KITTTITAS COUNTY COMMUNITY DEVELOPMENT SERVICES

April 10, 2019

RE: VA-19-00002 and SI-19-00002 – Deemed Incomplete and Request for Additional Information

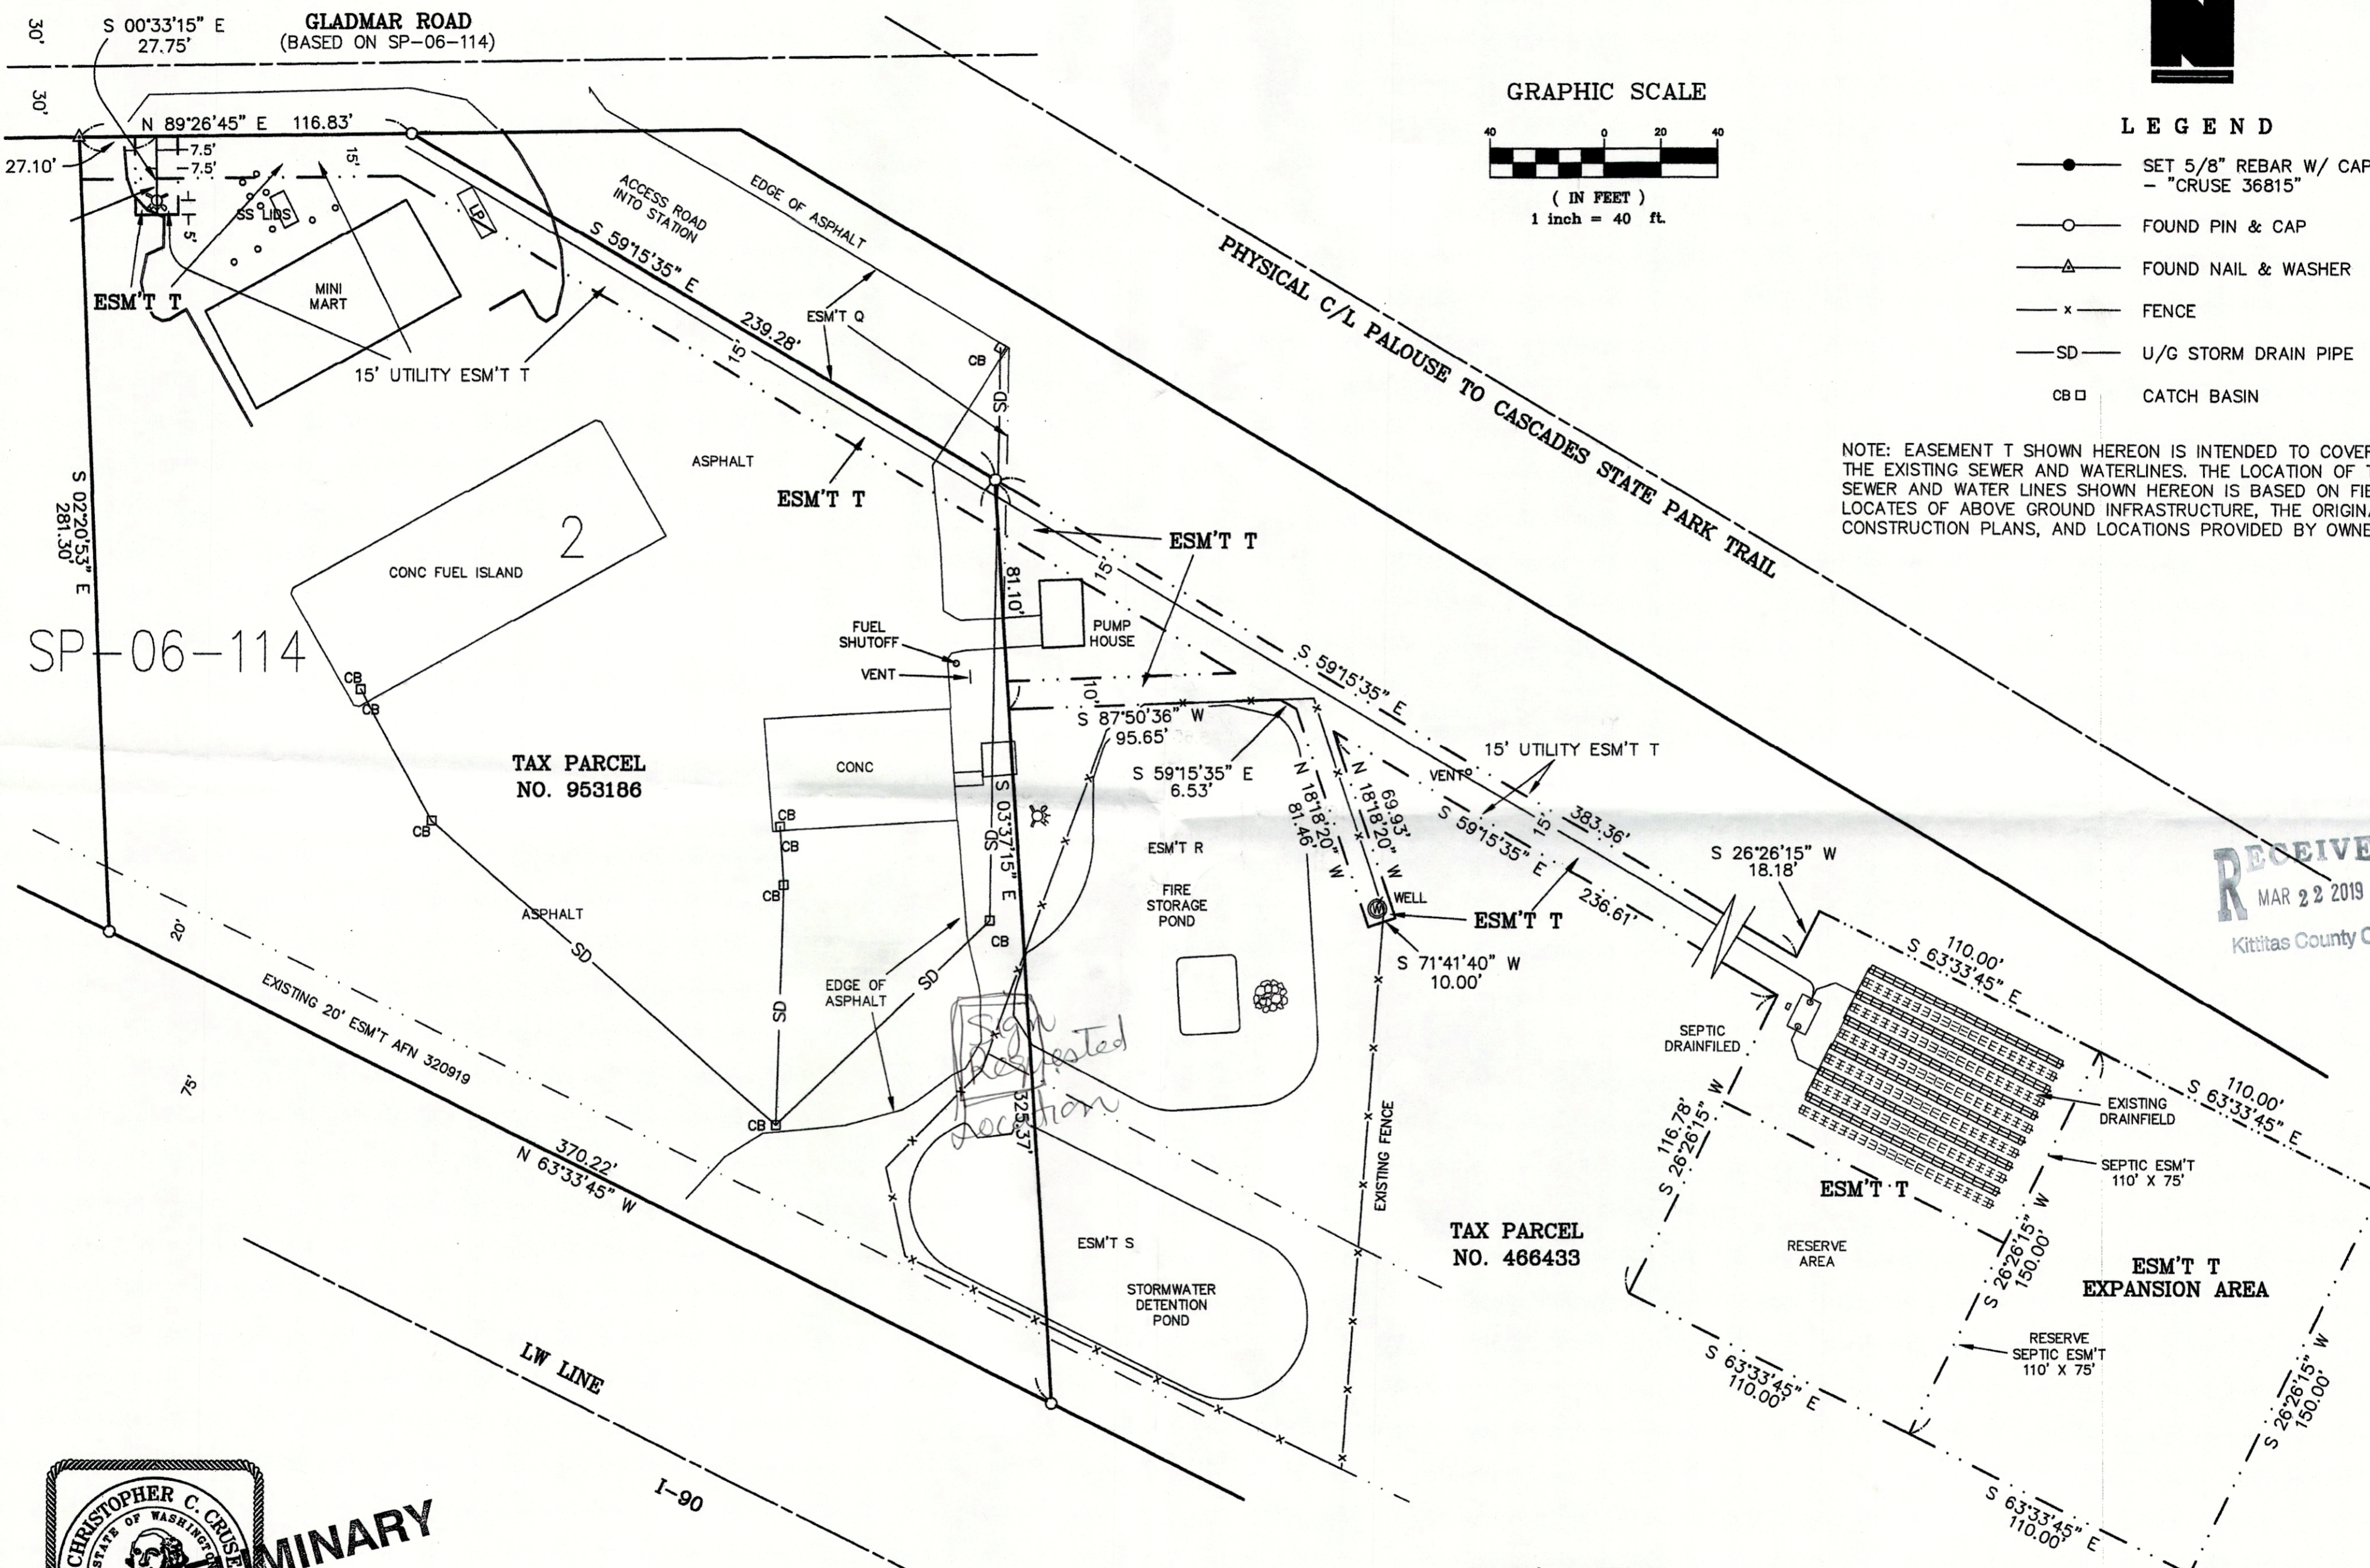
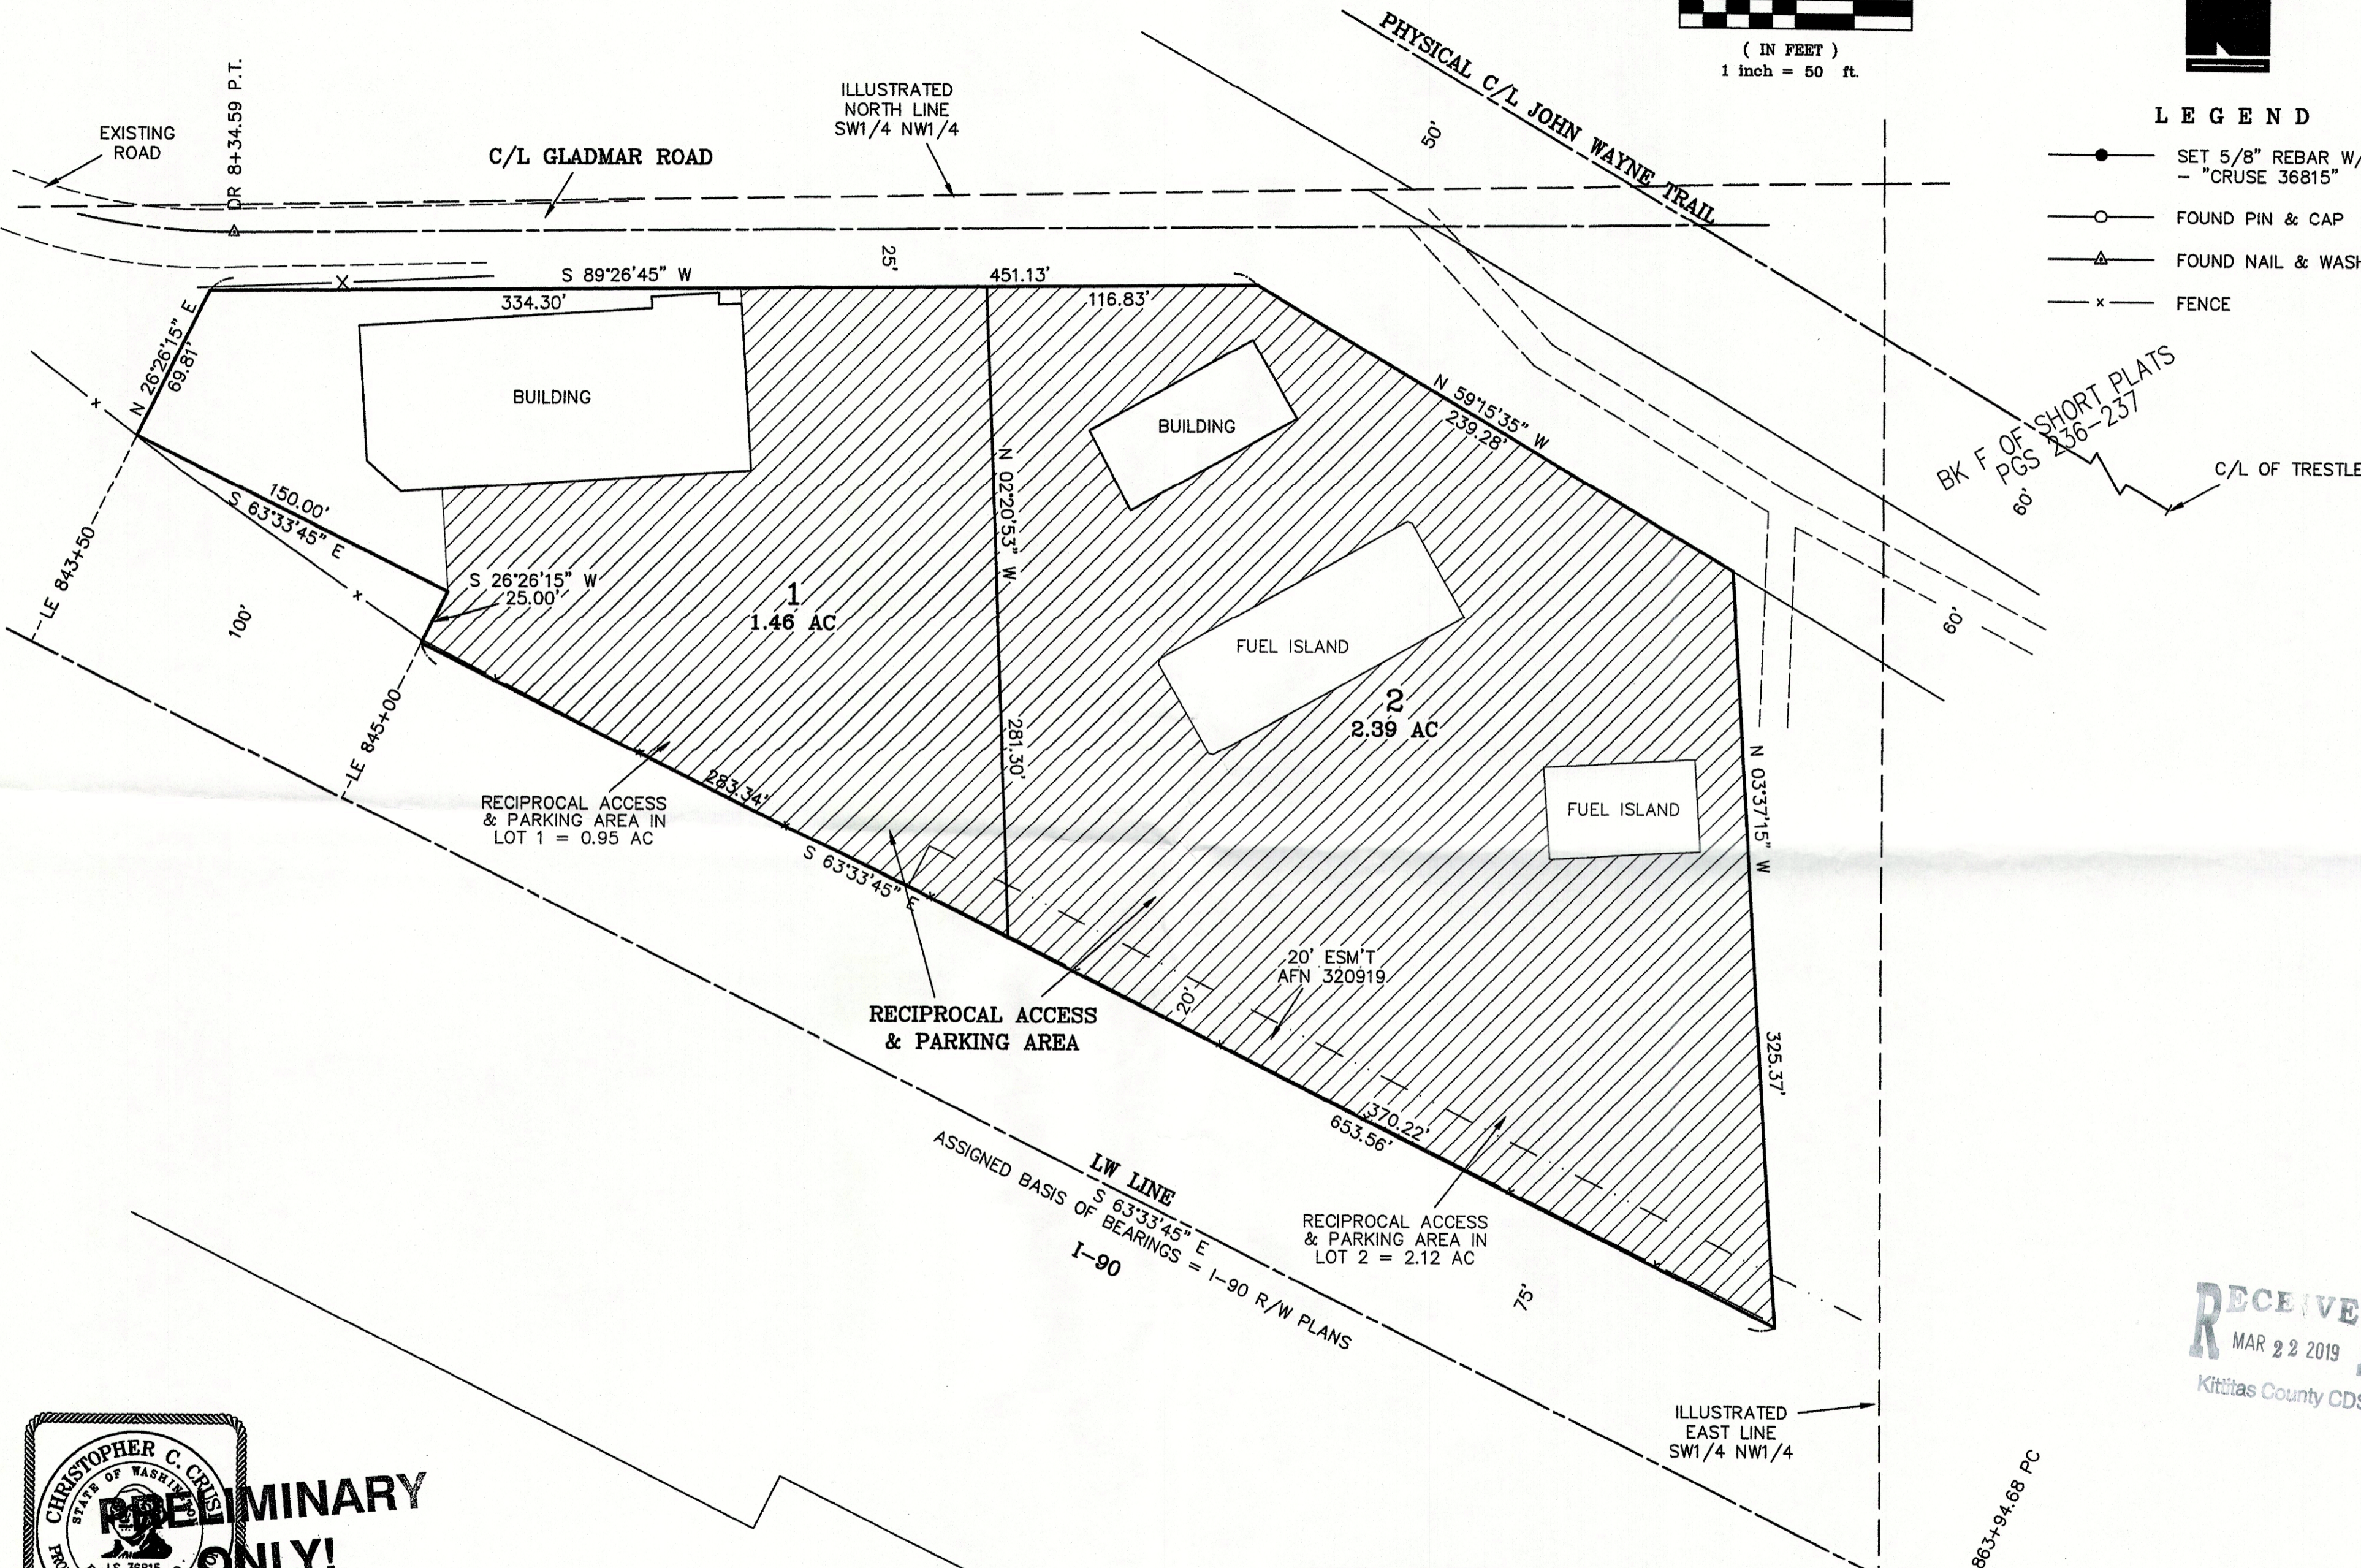
- C) The application does not indicate the likely fall radius of the proposed sign, nor does it show the dimensions from property lines to the sign. In order to continue processing of the application, revisions to the site plan are needed, indicating where the sign is likely to fall in the case of structural failure and collapse, and also show the dimensions from the edge of the sign post to the north, east, and southern property edges; in order to determine whether “*the granting of such variance will not be materially detrimental to the public welfare or injurious to property in the vicinity or district in which the property is located*” as required by item # 3 above.

1. A revised narrative detailing how the application meets the criteria for KCC 17.84.010(1), (2) and (3).
2. Additional information as to plans for the existing sign on the I-90 frontage.
3. A revision to the site plan depicting the likely fall radius in case of structural failure prepared and stamped by an engineer licensed in the State of Washington.
4. A revision to the site plan depicting the dimension from the base of the sign to the north, east, and south property lines.
